KIRKLEES METROPOLITAN COUNCIL INVESTMENT & REGENERATION SERVICE

DELEGATED DECISION TO DETERMINE PLANNING APPLICATIONS

Reference No:	2024/62/91462/W
Site Address:	30, Bank End Road, Bolster Moor, Huddersfield, HD7 4JN
Description:	Erection of single storey side extension, increase roof height to create first floor accommodation and erection of rear dormer windows
Recommending Officer:	Laura Yeadon

DECISION – CONDITIONAL FULL PERMISSION

GROUND FLOOR PLAN SCALE 1:50
AS PROPOSED

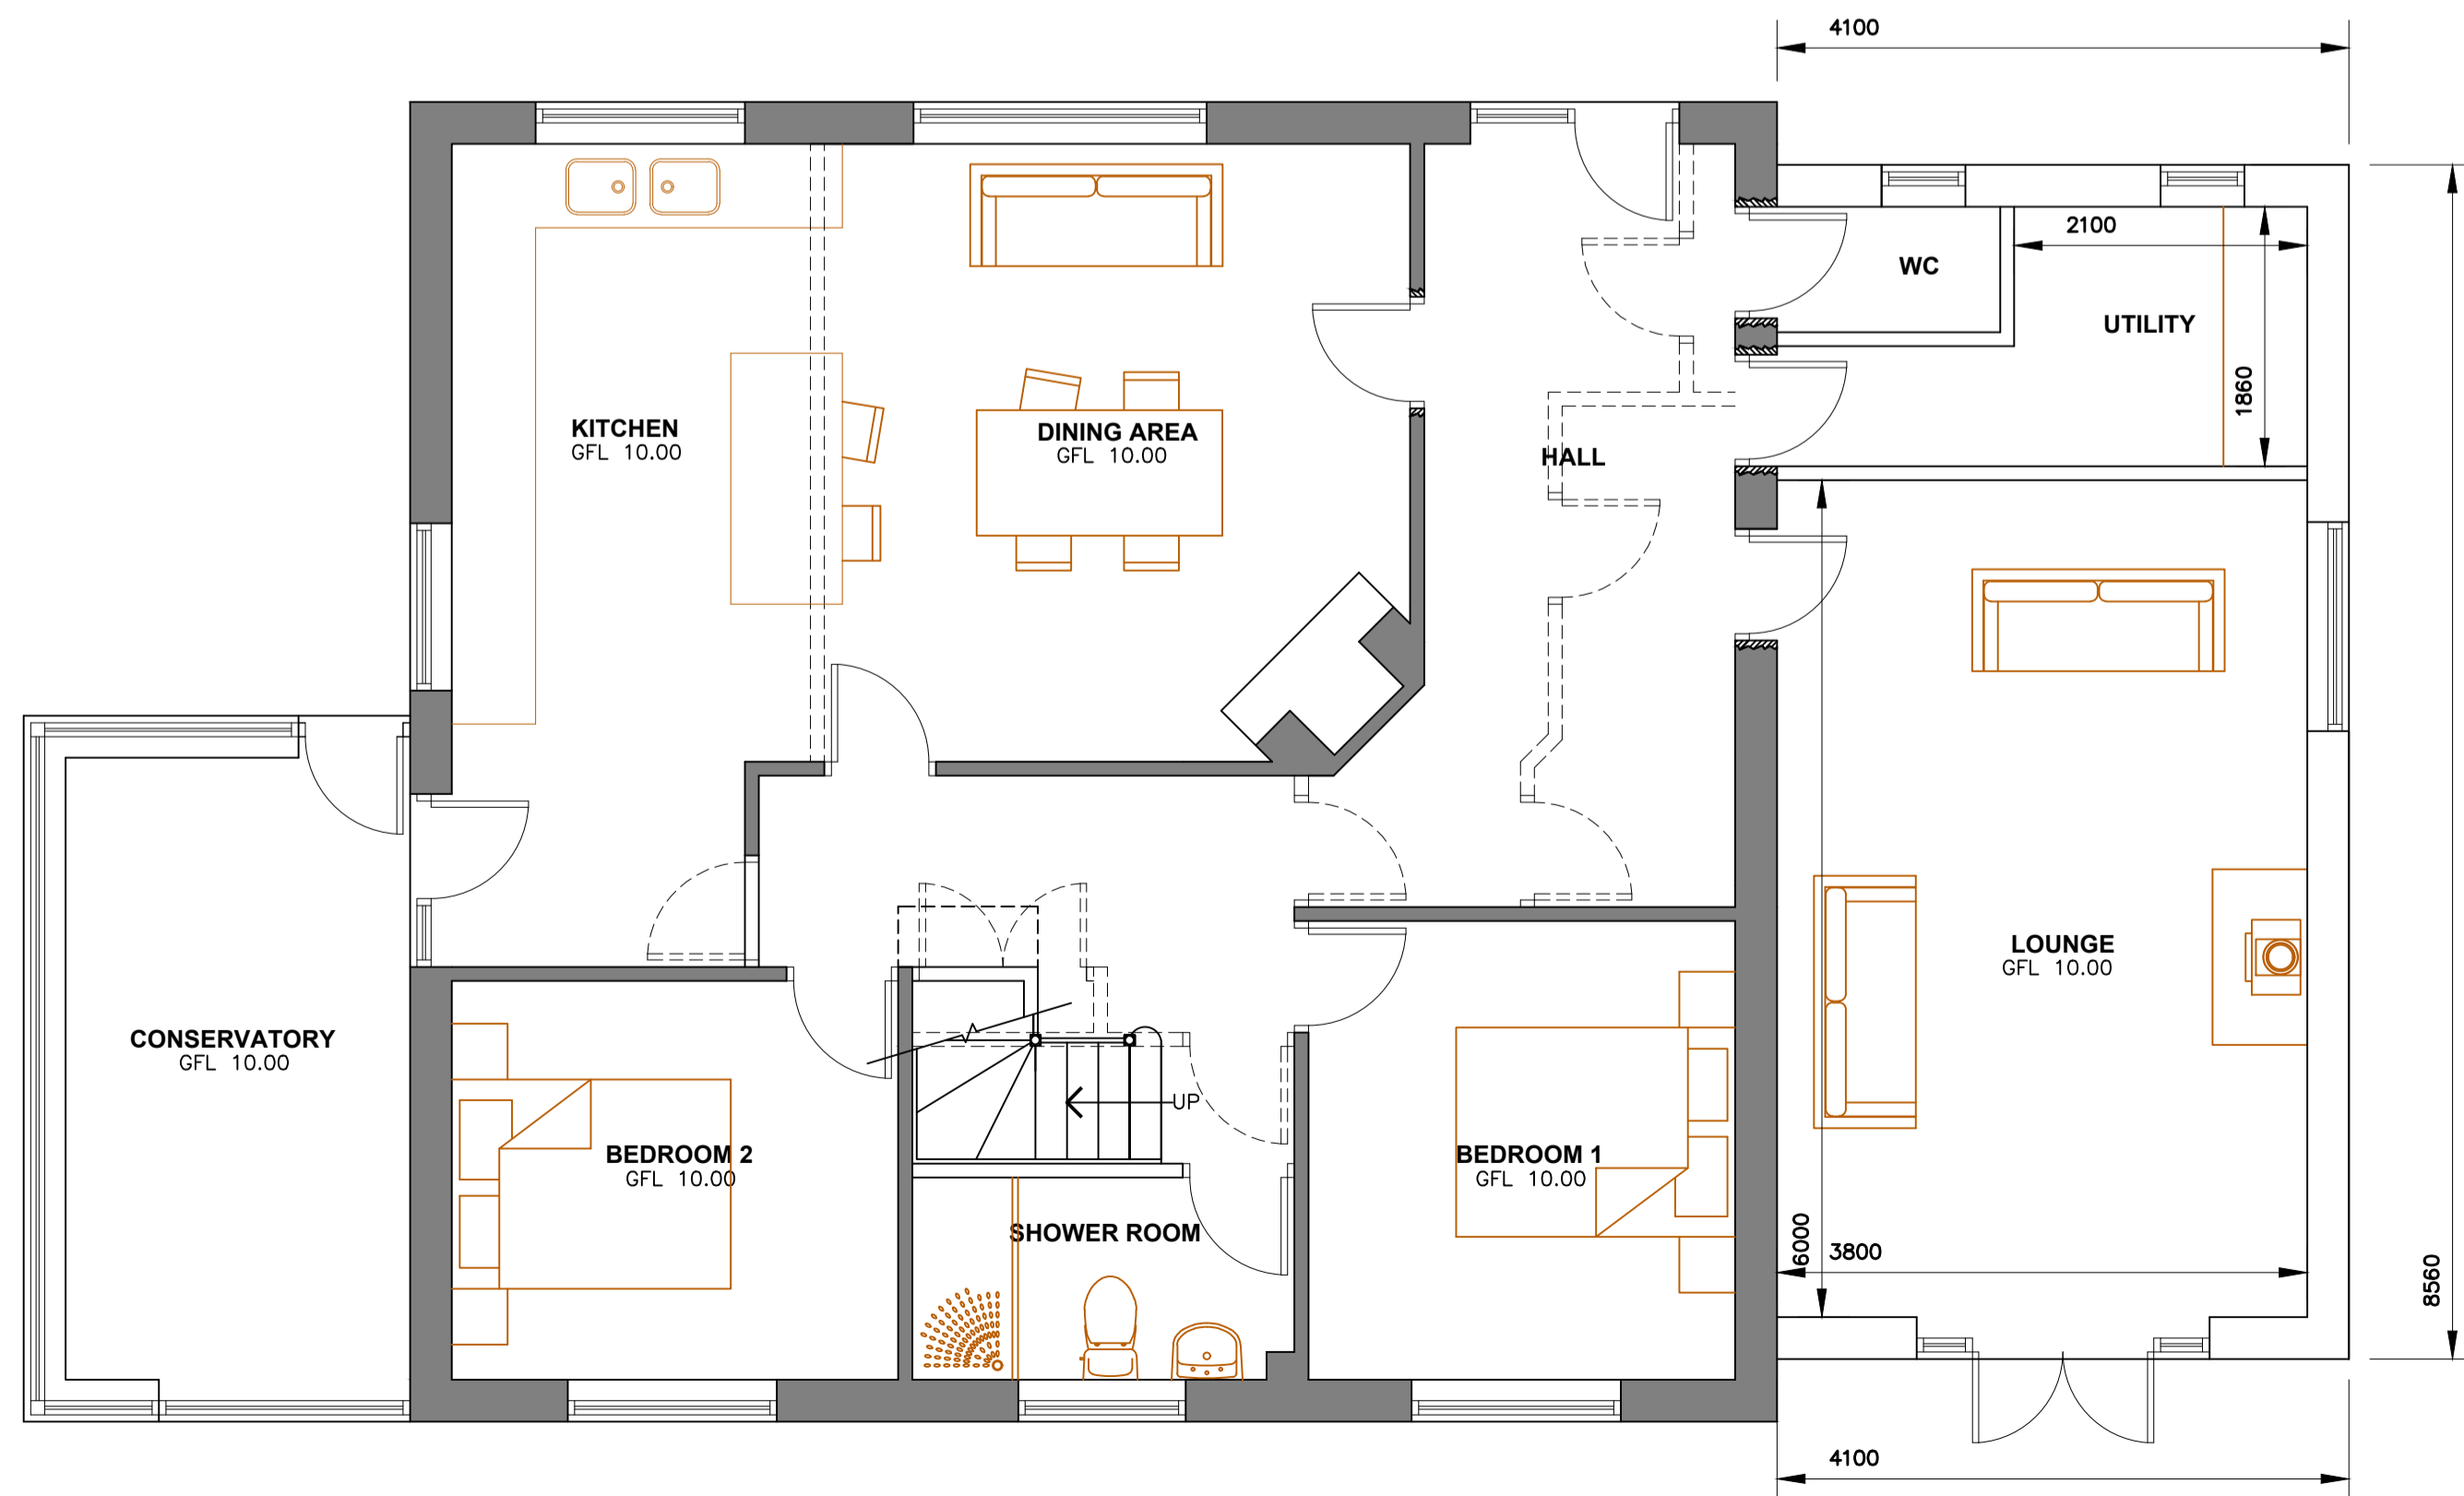
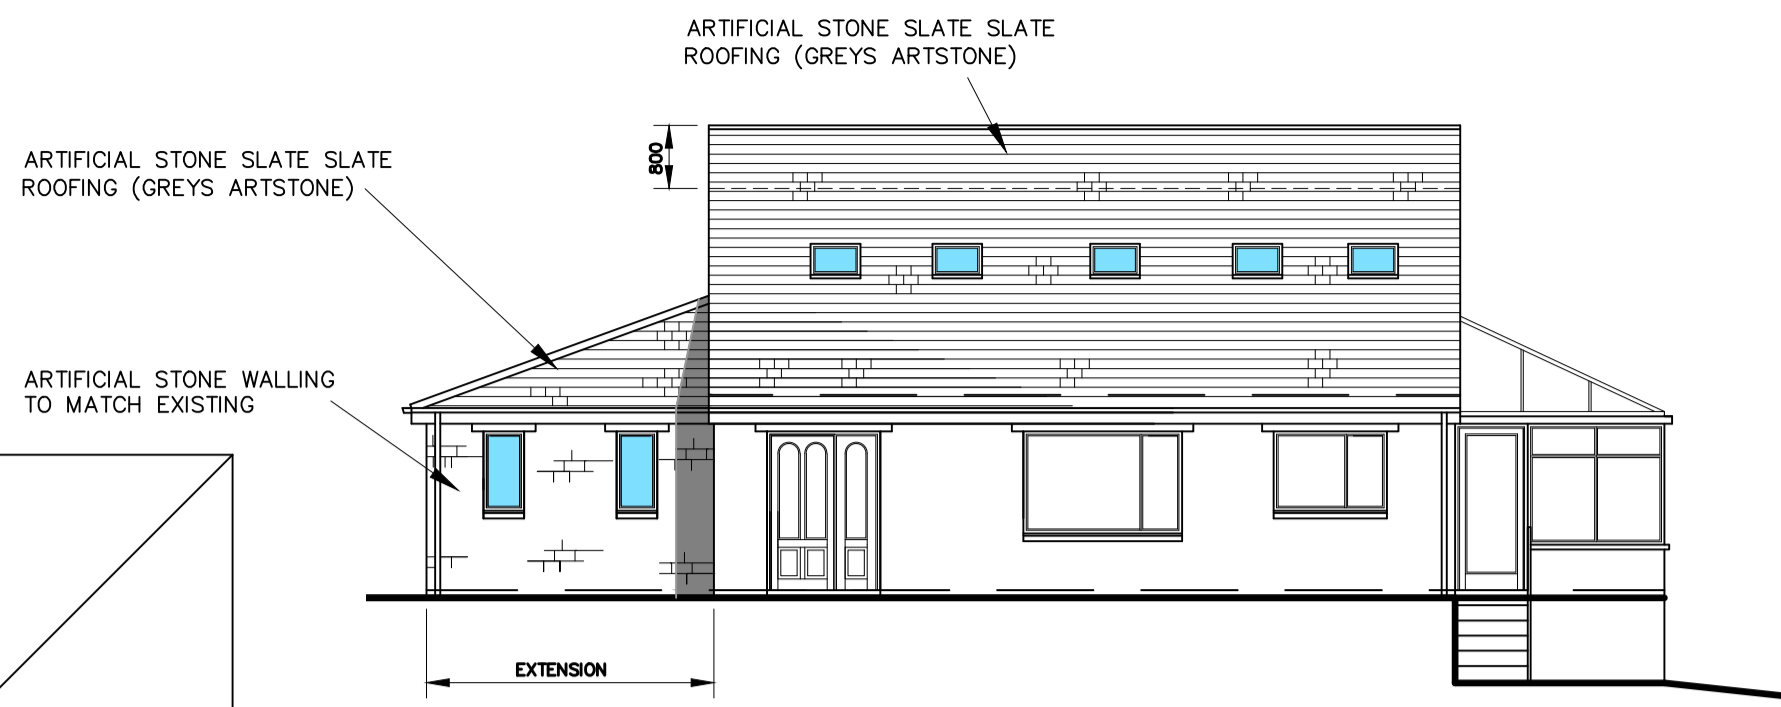
The proposed single storey side extension would be located on the western side of the dwelling facing the garden area to the property. The extension would be set back from the front elevation of the property by 0.6m and in from the rear elevation by 0.4 metres, projecting to the side by 4.1m. The eaves height would match the existing with an overall height of 4 metres to the ridge of the lean-to roof. The proposed extension would be constructed from artificial stone for the walls with artificial stone slate for the roof.

The resultant accommodation would be a lounge area, utility room and WC.

WEST ELEVATION SCALE 1:100
AS PROPOSED

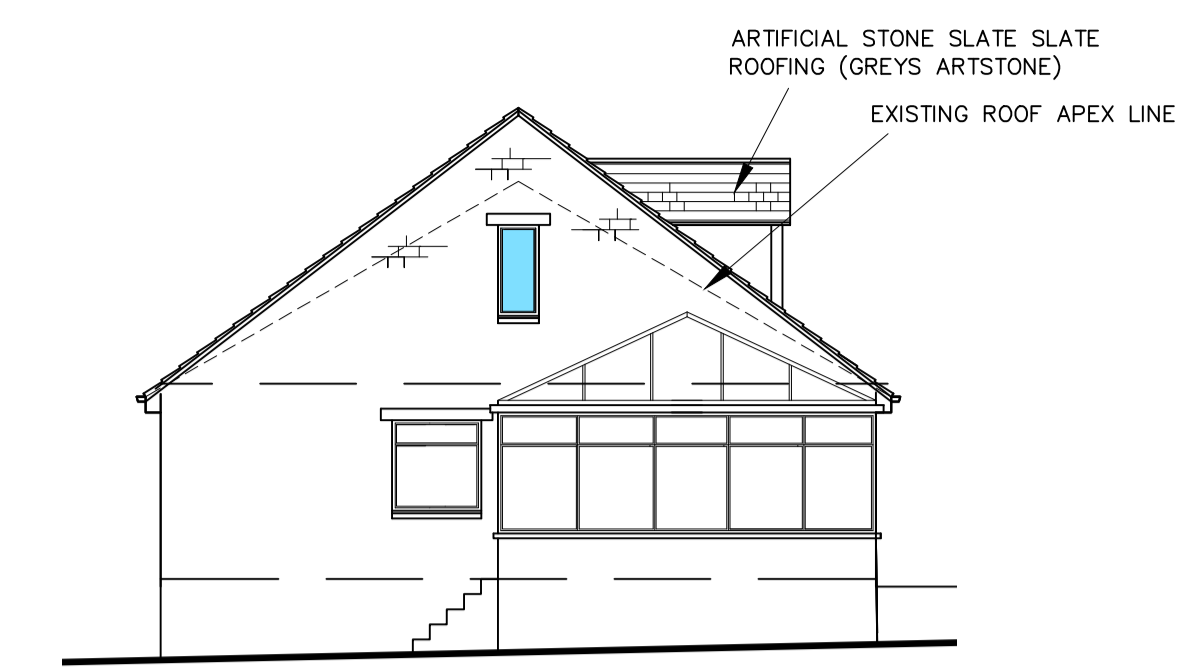
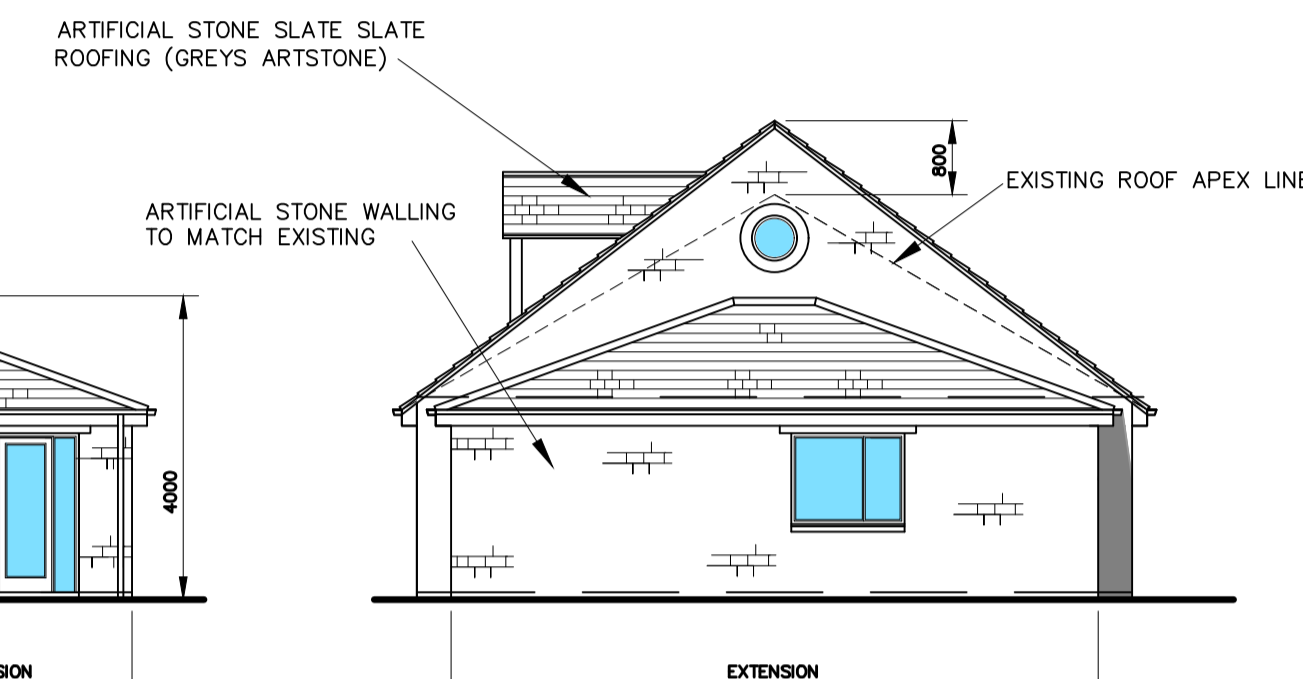
It is proposed that 2 no. dormer extensions would be located in the rear elevation roof slope. The dormers would appear as identical being a width of 1.5m, height of 2.2m, set up from the gutter line by 1m and down from the increased roof ridge by 1m. No details have been received with regards to the proposed construction materials for the dormer front or cheeks.

In terms of the side extension, this would not extend more than two-thirds of the width of the original dwelling, would not exceed 4 metres in height and would be set back from the front elevation of the property, therefore complying with the SPD.

The proposed dormers would relate to the house and proposed increase in roof height, they can be conditioned to be tile hung (in accordance with the previous permission) and would not dominate the roof. In addition, they would be set below the ridgeline, be set up from the gutter line and would be aligned with the openings within the rear elevation of the property. Therefore, the dormers are considered to comply with the requirements of the SPD.

4. The rear dormer extensions hereby approved shall be tile hung/clad to the front & cheeks in materials which match those used in the construction of the host property and shall be retained thereafter.
